Embrey Builders, LLC

RFI

RFI #: 182
Date: 8/13/2012
Job: EB-02 Keller Springs Lofts
Phone: 877-777-5115

Subject: 6" transition step on #19

S3.04

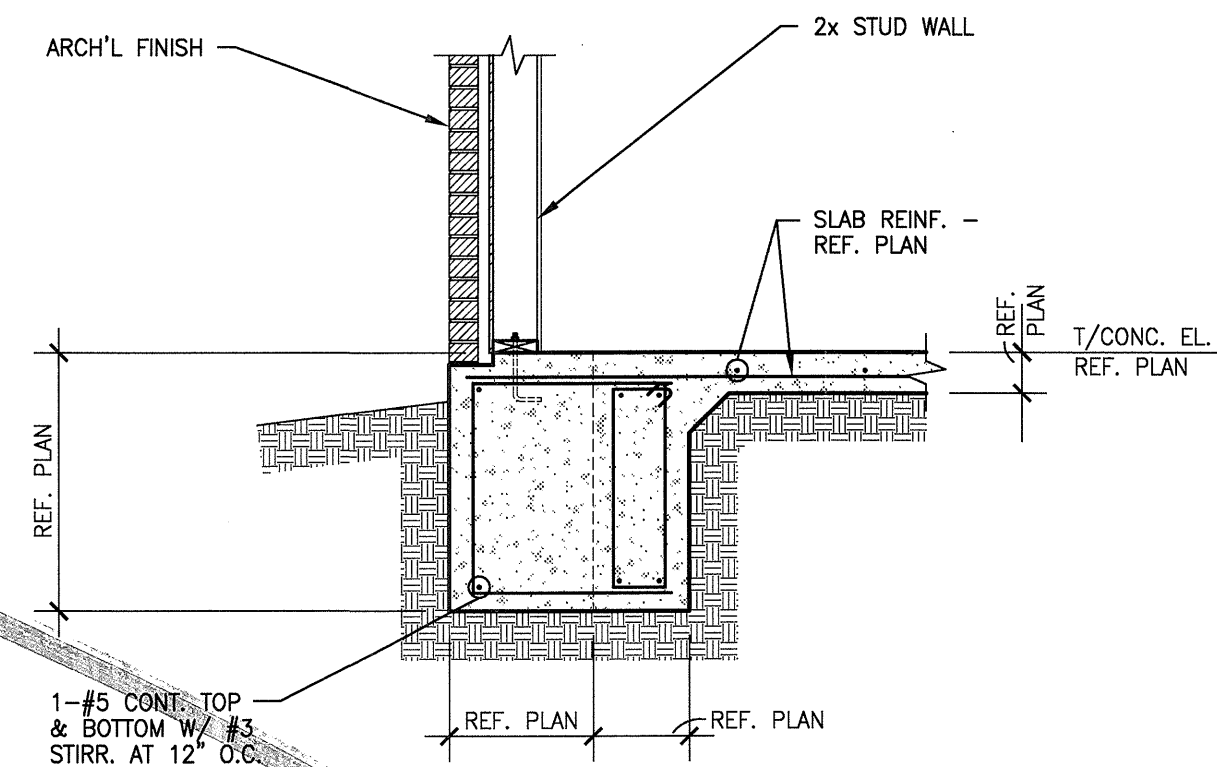
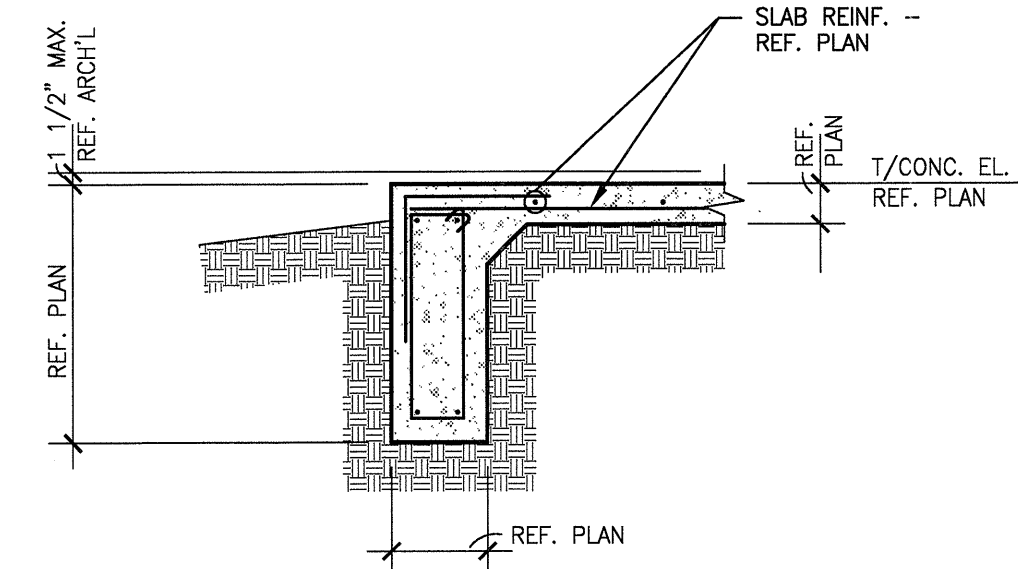
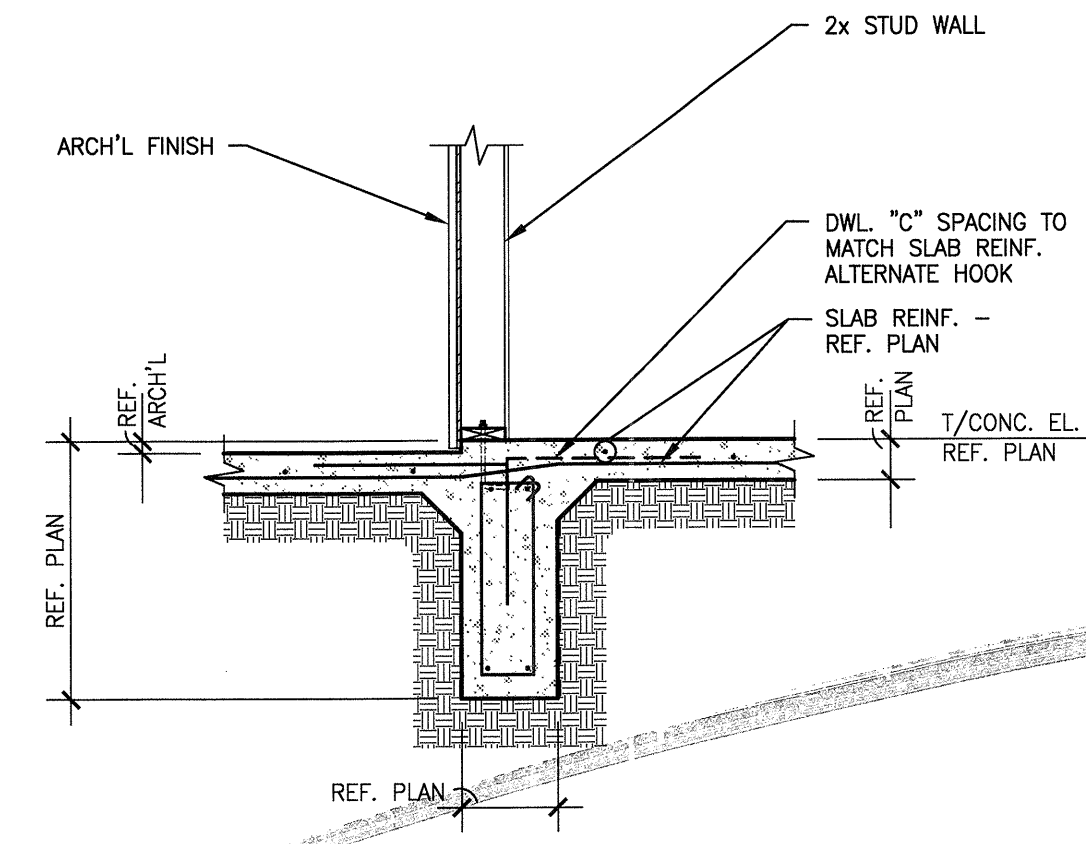
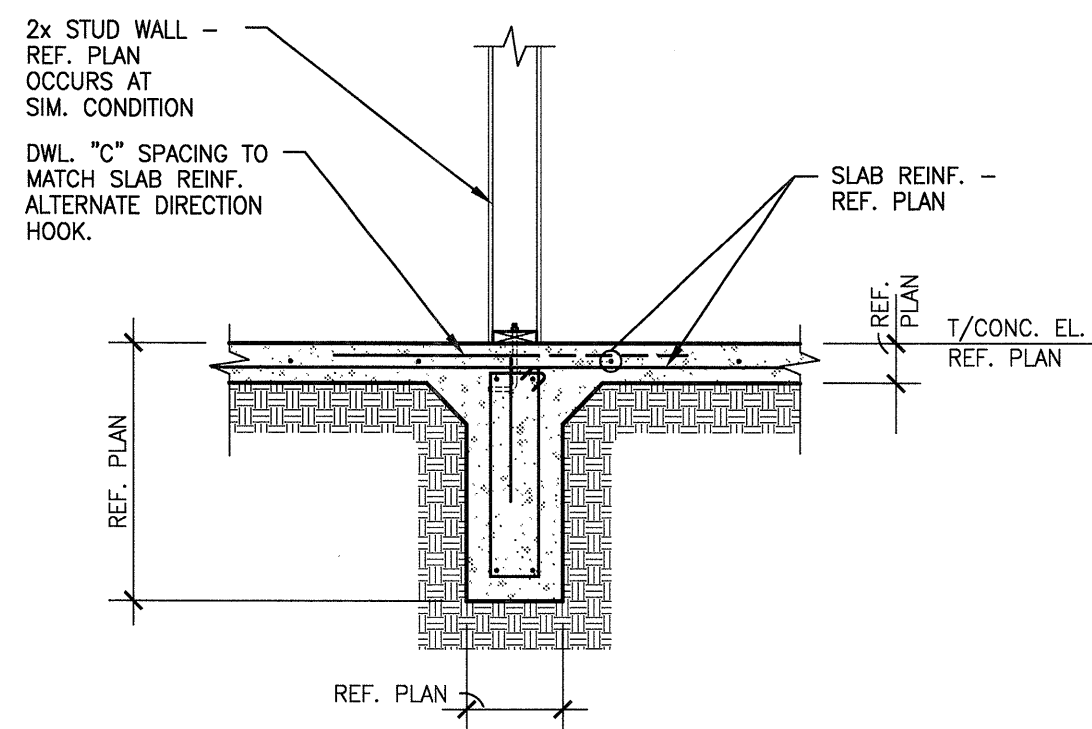
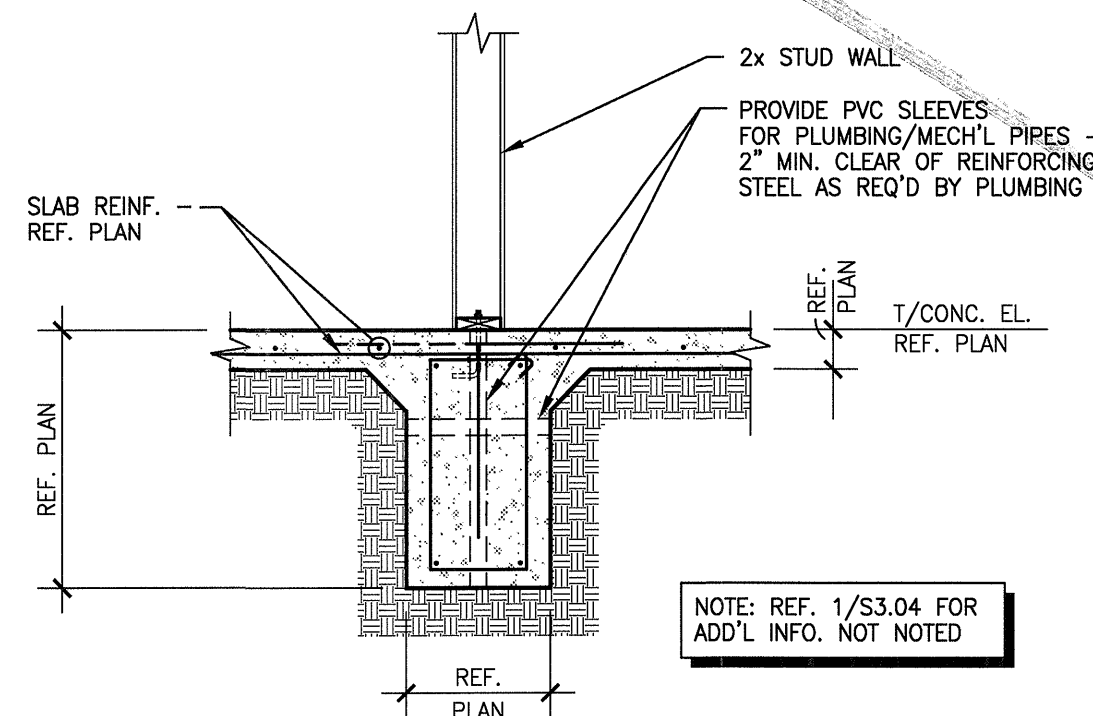
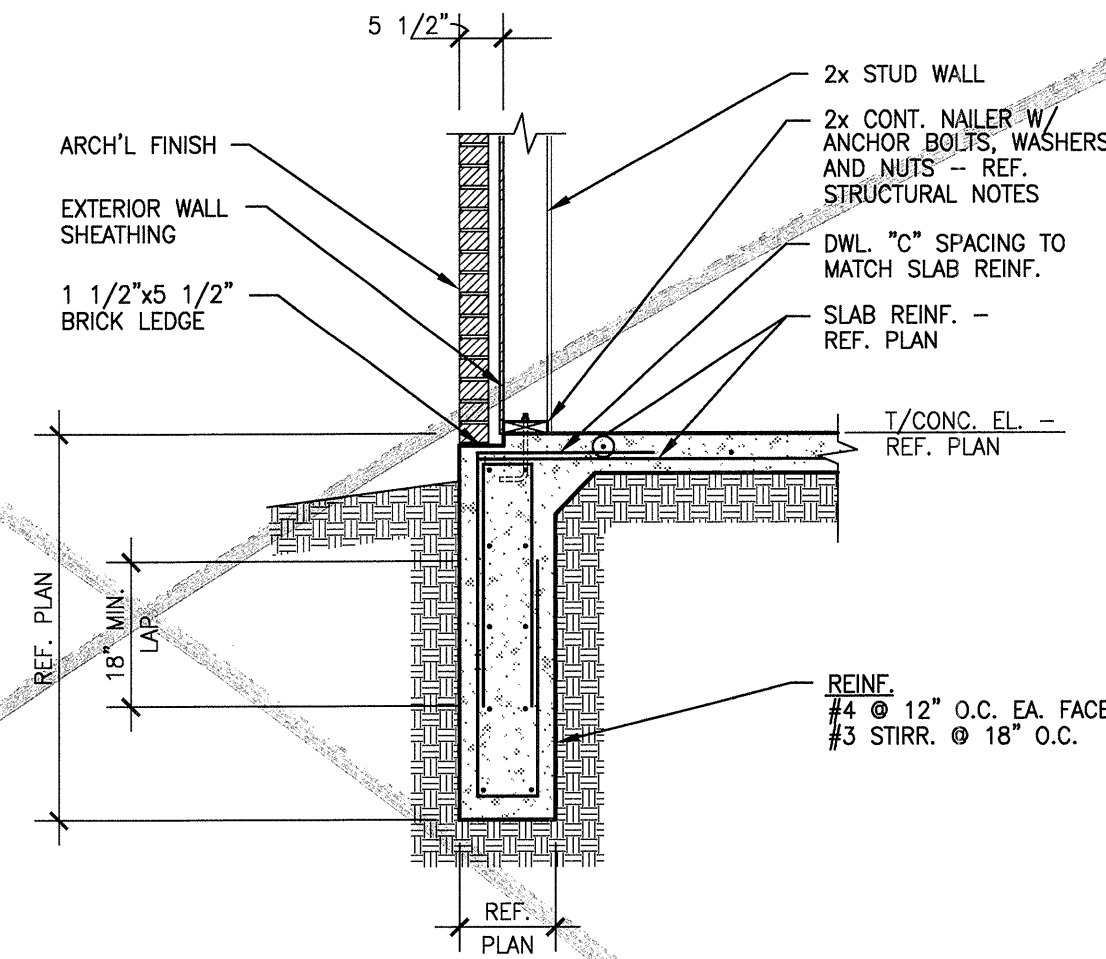
Request:
Trent,
We still have a question on the transition 6" step on #19. You had previously said that the soffit of the 10" slab and the 18" area was the same and that is the way detail 9/S3.04 shows it. However, the step is only 6" so when that is added to the 10" slab coming into the thickened area you only get 16" not 18". If you look at 10/S3.04 that detail does not reflect our situation on this pour. Please advise ASAP
Requested by: Bryan Pickler
Embrey Partners, Ltd.

Response:
You are correct. The slab thickness in this area should be 10" + 6" = 16" not 18". The 18" dimension in 10/S3.04 should be 16" instead.
Answered by: Trent Perkins
Parkin Perkins Olsen
Answered date: August 14, 2012
